From: Mark Warwick
Sent: 12 December 2018 14:08
To: Michael Eastham
Cc: Planning.Responses
Subject: RE: AL/20/18/OUT - Bridge Cottage and the Old Cottage, Lidsey

I have considered the revised illustrative layout plan. Although a slight improvement from the original layout as it seeks to respect the existing Root Protection Area of preserved trees (TPO); there remains an unacceptably high number of moderate-high quality trees proposed for removal across the site and inadequate space around the most significant individual trees (T07 maidenhair, T29 oak and T44 beech) to facilitate and accommodate future growth above and below ground.

Rev B 10/07/18 House Footprints amended.

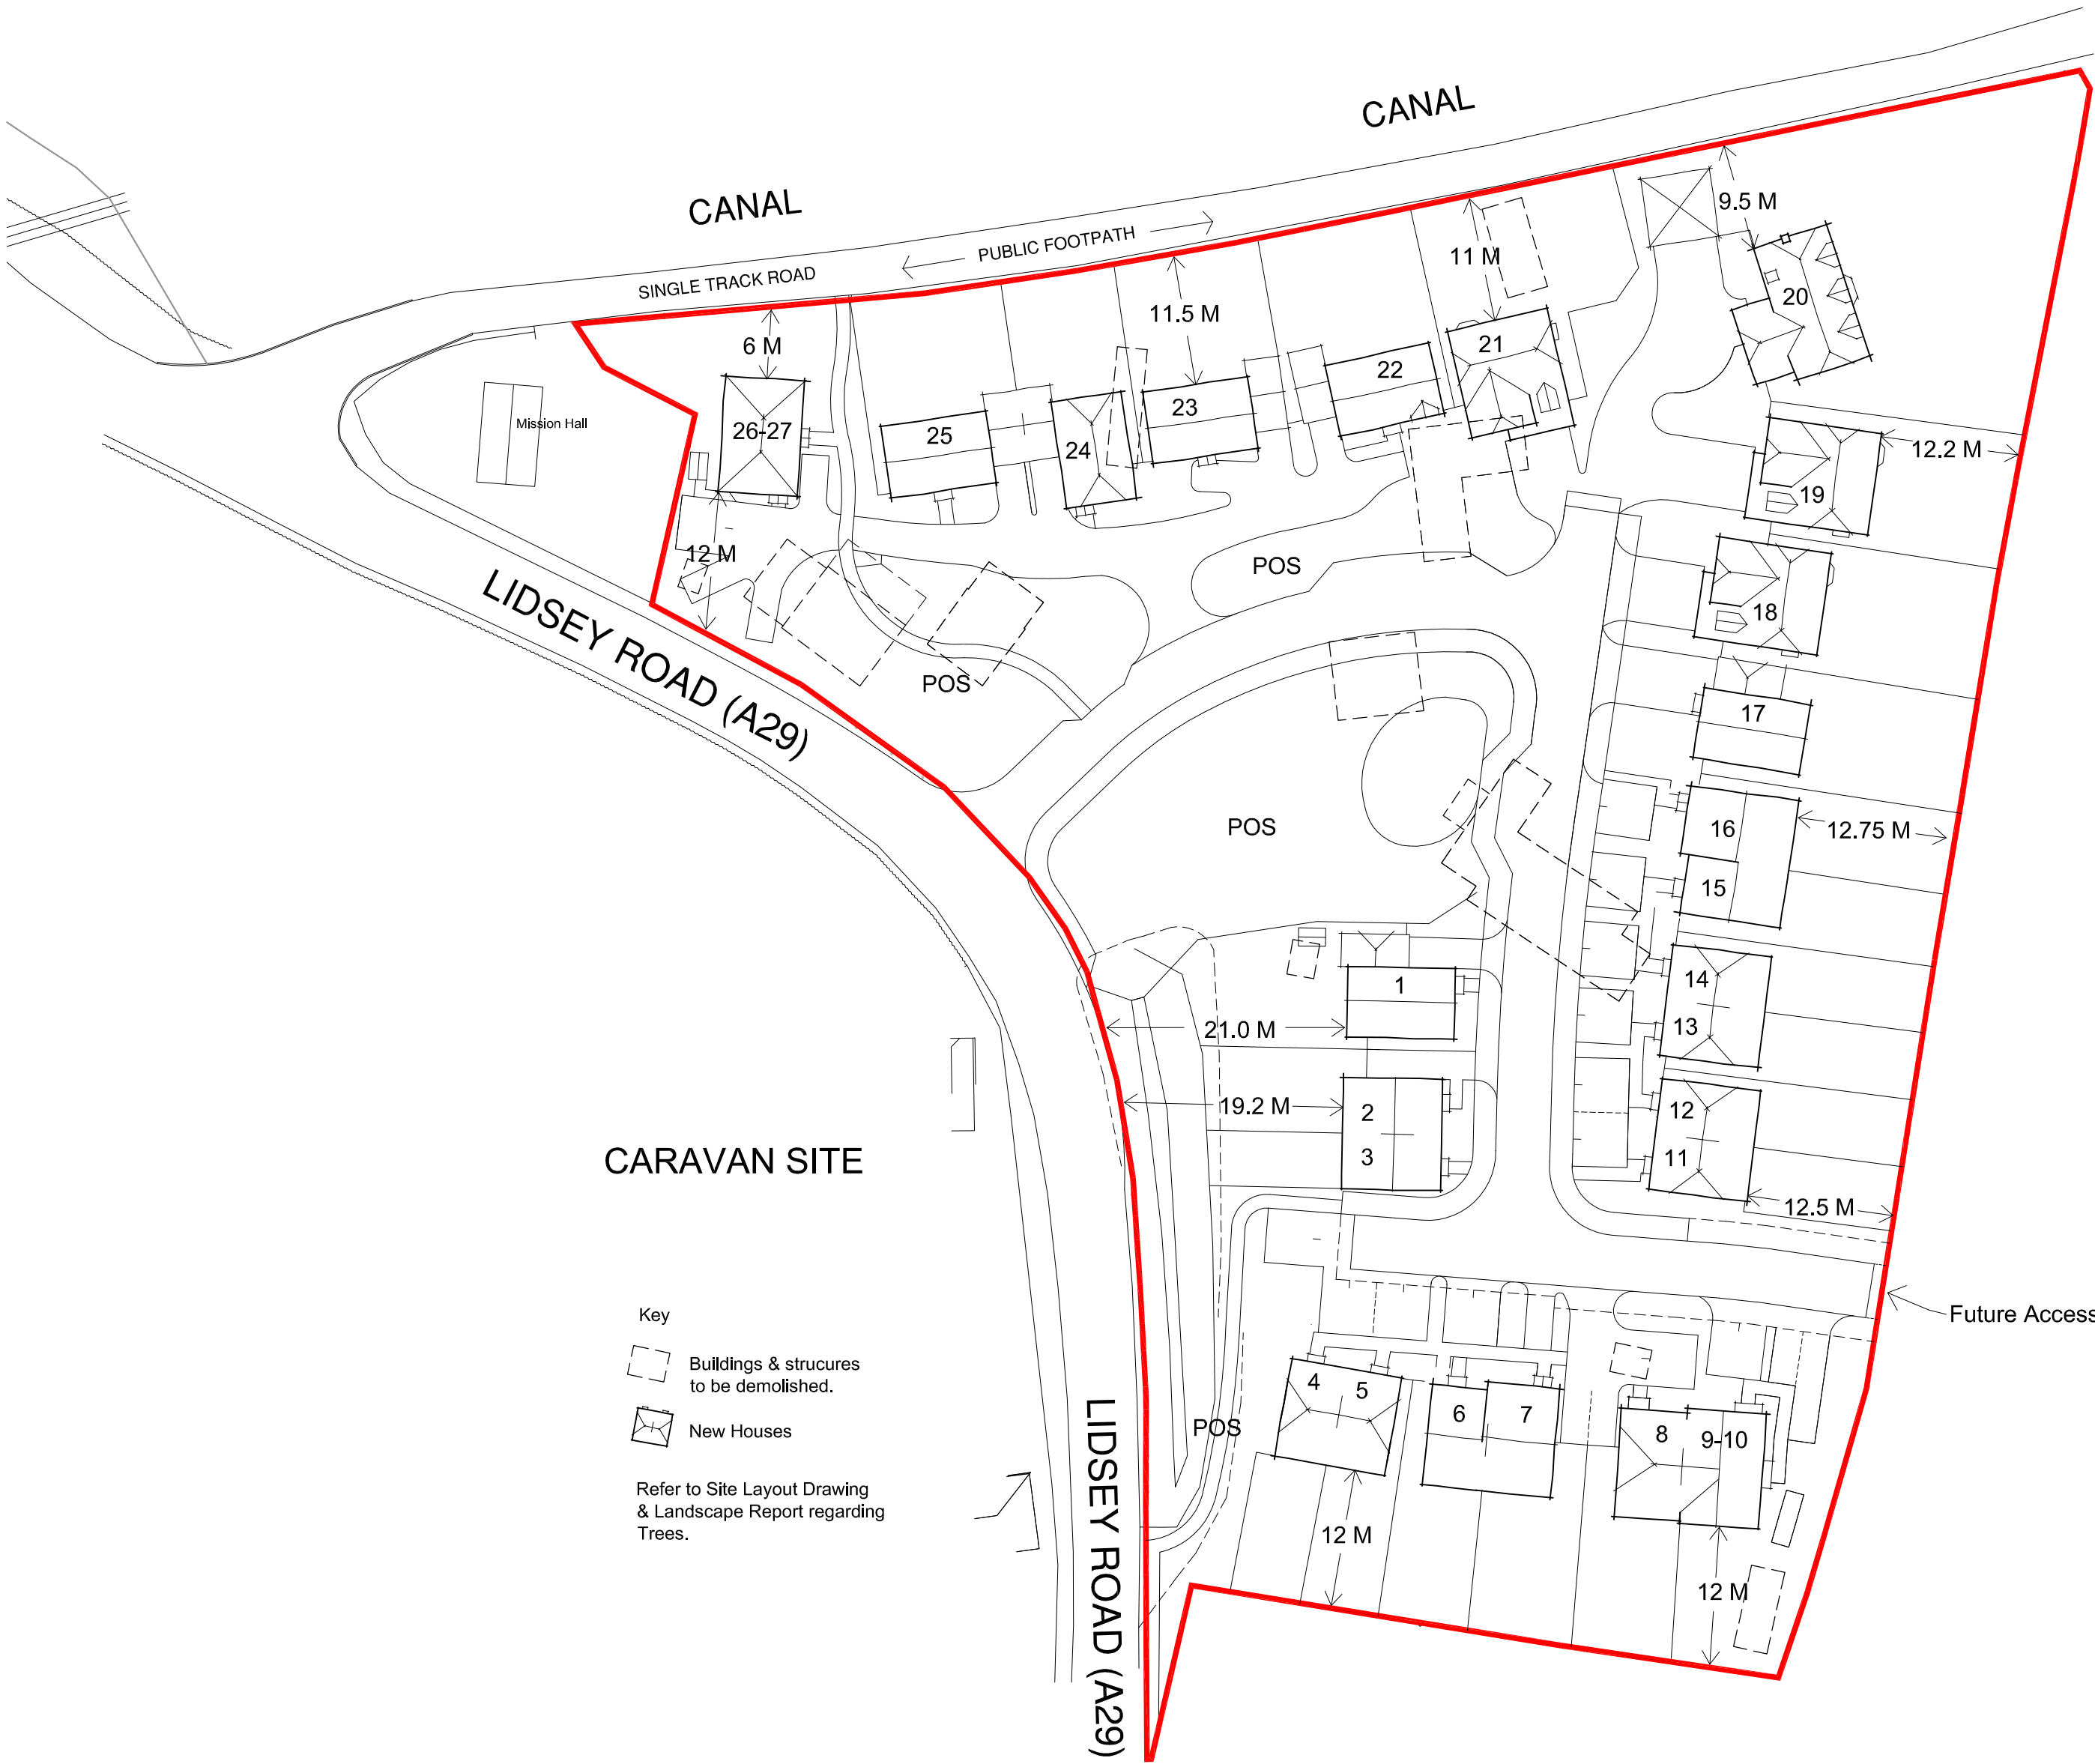
As such, I must sustain an Objection until such time as the above issues are satisfactorily resolved.
